2b Well Road
Pagham
Bognor Regis
West Sussex
PO21 4SR

Re Planning Application P/74/13 - 2 Lagoon Road, Pagham

REAR

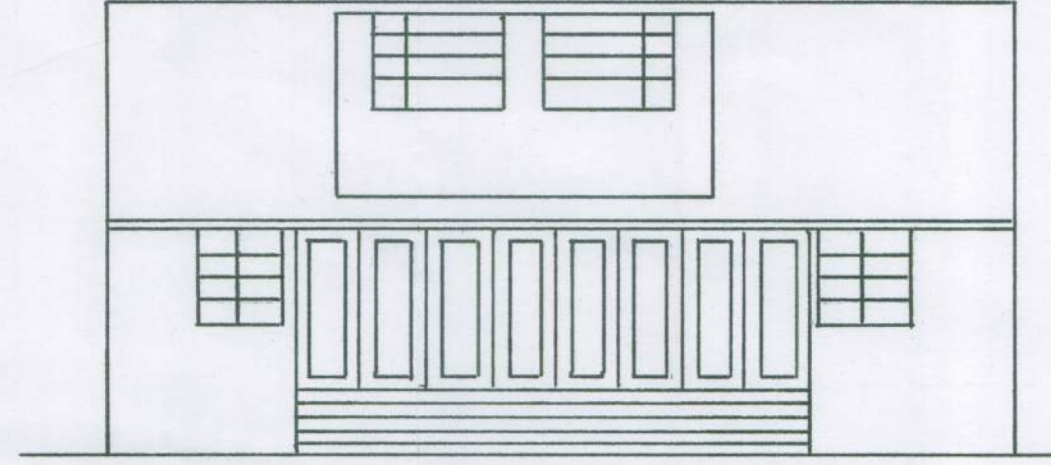
Rear dormer

- a. I believe it will have an adverse affect on the character of the Pagham Beach Estate which is for Single Storey Dwellings only. (I do understand that there is already an upstairs and front dormer in this property, which in itself is an anomaly).
- b. If passed, it could set a precedent and the flood gates would be opened for roof extensions in other properties, thereby changing the whole appearance of this unique location.
- c. It would overlook Nos. 2b and 2c Well Road, thereby invading their privacy.
- d. In my opinion, the whole Roof Extension looks far too large and out of proportion for the existing property.

Roof Materials

I am perplexed as to why this is to be of copper and not the usual tiles as used on new and other updated properties in the vicinity.

I feel this would not be in keeping with other nearby properties and stand out like a 'Sore Thumb'.

REAR WALL & GARAGE

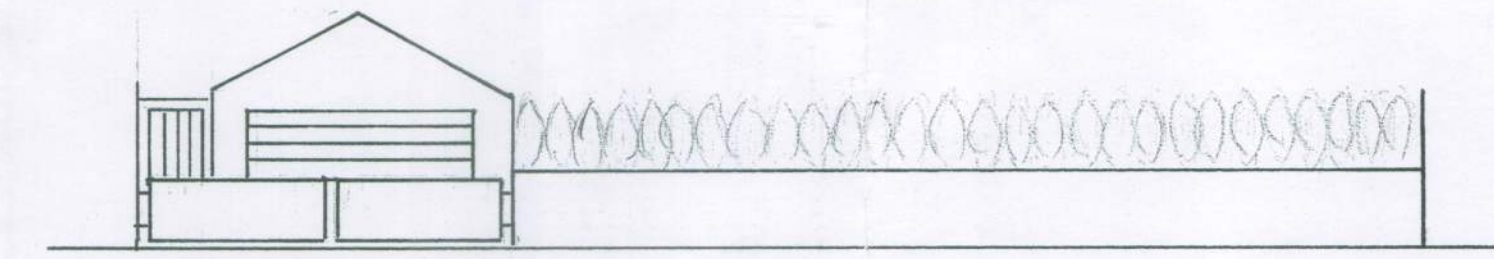
New Rear Boundary Wall

I object. How can a wall be built on land that does not belong to this property?

This wall appears to follow the same line as the recently constructed fence. (Subject of a Planning Appeal)

I enclose a copy of Land Registry No. SX6106 for 2 Lagoon Road dated 1st Sept 2013. The Plan submitted by the Applicant differs to the above and shows the rear boundary moved to encompass land immediately adjoining Well Road. I know that railway carriages have been demolished and new bungalows built over the years but no new rear boundary for No 2 Lagoon Road appears to have been registered.

I would have no objection to a wall being erected along the original rear boundary line as per the Land Registry No SX6106.

Leaving a strip of land between the road and the new boundary wall would be more pleasing and nature friendly.

SITE PLAN 1:200

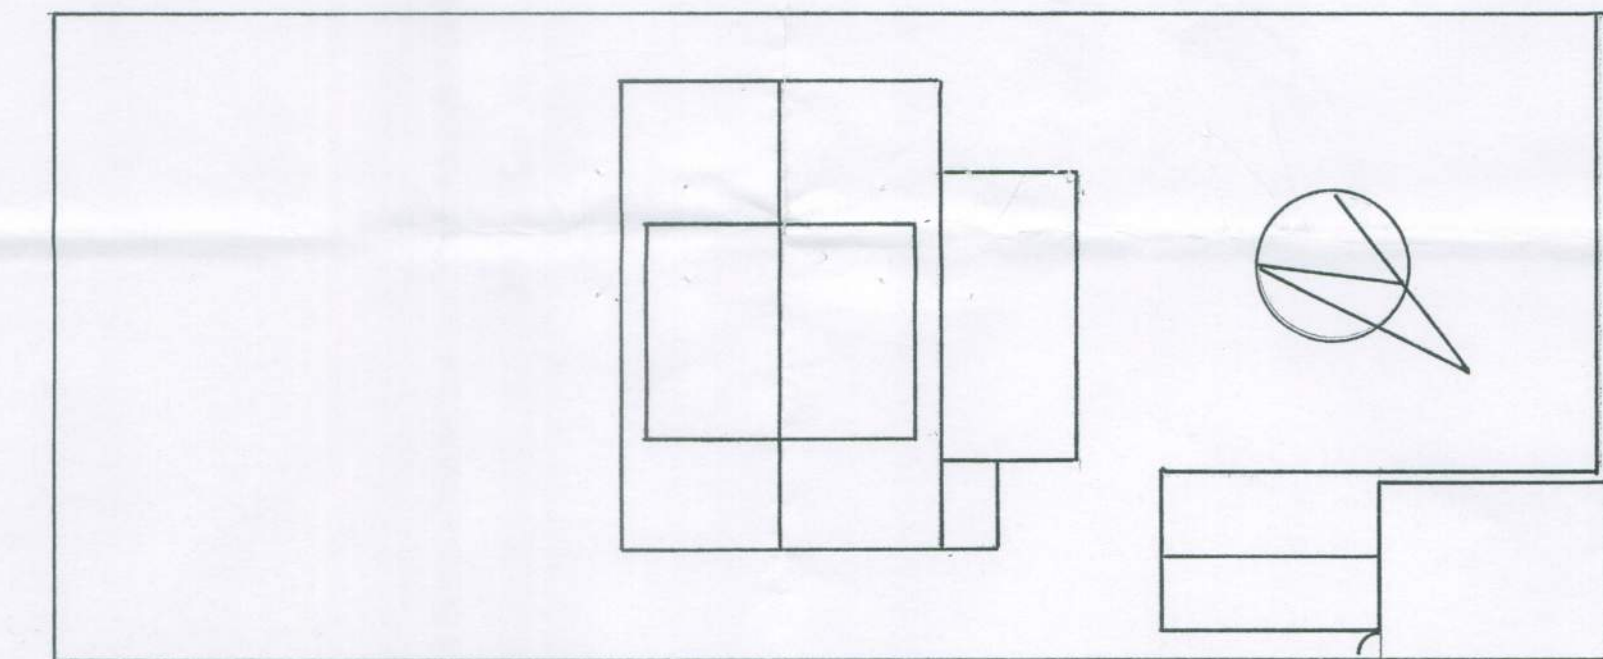
I have spoken to Pagham Beach Holdings Ltd who informed me that this annexed strip of land is owned by them and is subject to an ongoing legal dispute.

If the Applicant does not own the land adjoining Well Road, would it therefore mean that the garage would have no legal Access from Well Road?
